**WELWYN HATFIELD BOROUGH COUNCIL
EXECUTIVE DIRECTOR - PLANNING, PUBLIC PROTECTION AND GOVERNANCE**

DELEGATED APPLICATION

Application No: 6/2017/0905/HOUSE
Location: 2 Waterworks Cottages, Northaw Road East, Cuffley, Potters Bar, EN6 4RB
Proposal: Erection of single storey front, side and rear extension, front porch, clipped gable hip roof enlargement, 3x front dormers, 1x rear dormer, 1x side roof light and alterations to openings.
Officer: Mr D Elmore

Recommendation: Refused

Roof Plan

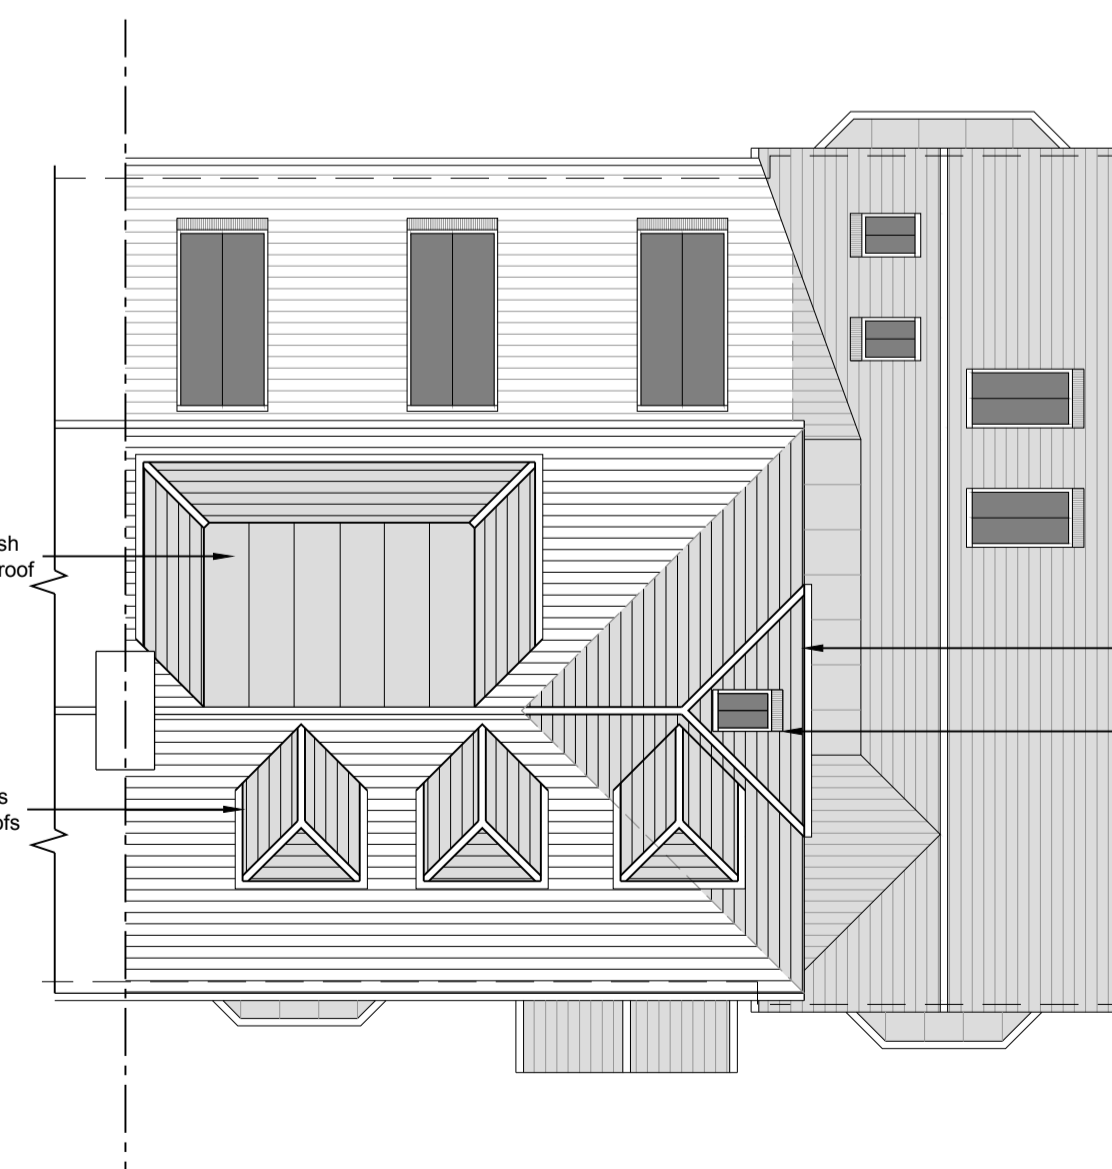
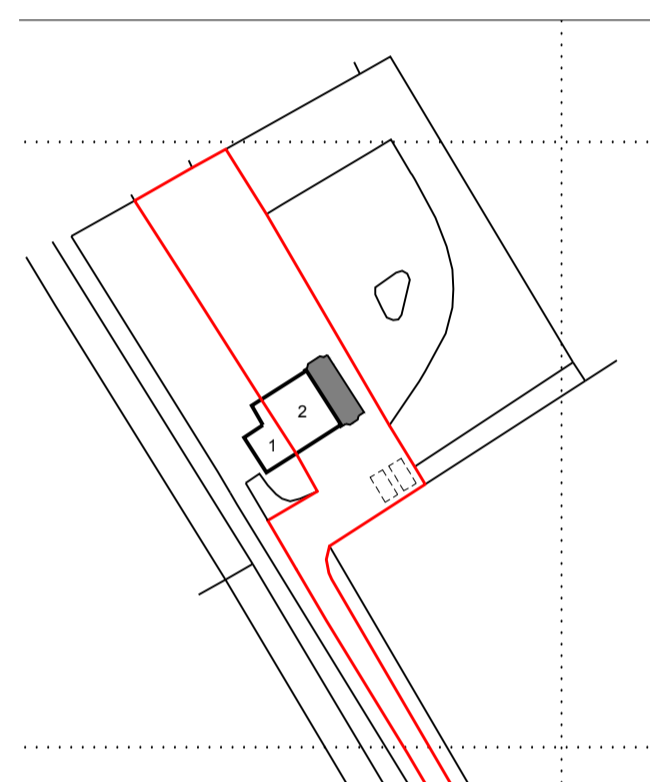
<p>Design (form, size, scale, siting) and Character (appearance</p>	<p>The proposed front, side and rear extension would feature a pitched roof (front and rear gables) and connect to the existing single storey rear extension in a 'wrap-around' effect. The roof connection of this proposed extension to the flank wall of the dwelling and with the mono-pitched roof the existing rear</p>

within the streetscene)	<p>extension would appear awkward and contrived. Furthermore, the use of a front gable ends would fail to complement and reflect the design and character of the existing dwelling.</p> <p>The existing dwelling features a hip-end roof. It is proposed to alter and enlarge this roof to form a clipped gable roof. The original pair of cottages featured hip-ends and No. 1 has altered its roof from hip to gable, including a rear dormer under what appears to be permitted development. The Council however have no record of a lawful development certificate for this property. Considering the gable ended roof of No. 1, the proposed clipped gable roof enlargement would adequately maintain the existing character of the semi-detached pair and is therefore considered acceptable, subject to roof tile matching that of the host property.</p> <p>Now turning to the proposed dormer windows. Section 5, 5.2(vi) of the Council's Supplementary Design Guidance 2005 (Statement of Council Policy 2005) states that "<i>dormer windows should be contained within the roof slope, be subservient to the roof of the property and be in proportion to the existing fenestrations of the property. They must not extend above the ridge height of the existing dwelling and the dormer cheeks should be at least 1 metre from the flank wall of the property or the party wall with the adjoining property.</i>"</p> <p>The proposed rear dormer would only be set in 0.4 metres from the flank wall with the adjoining property and therefore fails to meet the minimum 1 metre set in distance as stipulated above. Furthermore, this rear dormer, by virtue of its width and height, would dominate the resultant roof slope. Accordingly, this element of the proposal would represent a poor standard of design.</p> <p>Notwithstanding the unacceptability of the rear dormer, the proposed front dormers are modest in their scale, in proportion to the existing fenestrations of the property and their pitched roofs would complement the principal roof form.</p> <p>The proposed front porch would be subordinate in scale to the host dwelling and has a limited depth so as to ensure that it is not prominent.</p>

The proposed rear dormer, by virtue of its width and height, would fail to be subservient to the roof of the property and, given its positioning on the roof slope, would fail to provide effective relief from the party wall with the adjoining property. Accordingly, this element of the proposal represents a poor standard of design, contrary to Policy D1 of the Welwyn Hatfield District Plan 2005, Supplementary Design Guidance 2005 (Statement of Council Policy) and National Planning Policy Framework 2012.

1. The proposed development results in disproportionate additions over and above the size of the original building and therefore represents inappropriate development within the Green Belt. Furthermore, the increased bulk, footprint and massing of the proposed development would result in a loss of openness and visual permeability of the Green Belt. Very special circumstances do not exist. Accordingly, the proposal is contrary to Policy GBSP1, GBSP2 and RA3 of the Welwyn Hatfield District Plan 2005 and National Planning Policy Framework 2012.

2. The roof design of the proposed front, side and rear extension would connect to the existing flank wall and single storey rear element in an awkward and contrived manner. Furthermore, the use of a pitched roof with front gable would fail to be in keeping with the design and character of the existing dwelling. As such, this element of the proposal would represent a poor standard of design which would fail to complement and reflect the design and character of the existing dwelling, contrary to Policy D1 of the Welwyn Hatfield District Plan 2005, Supplementary Design Guidance 2005 (Statement of Council Policy 2005) and National Planning Policy Framework 2012.

3. The proposed rear dormer, by virtue of its width and height, would fail to be subservient to the roof of the property and, given its positioning on the roof slope, would fail to provide effective relief from the party wall with the adjoining property. Accordingly, this element of the proposal represents a poor standard of design, contrary to Policy D1 of the Welwyn Hatfield District Plan 2005, Supplementary Design Guidance 2005 (Statement of Council Policy 2005) and National Planning Policy Framework 2012.
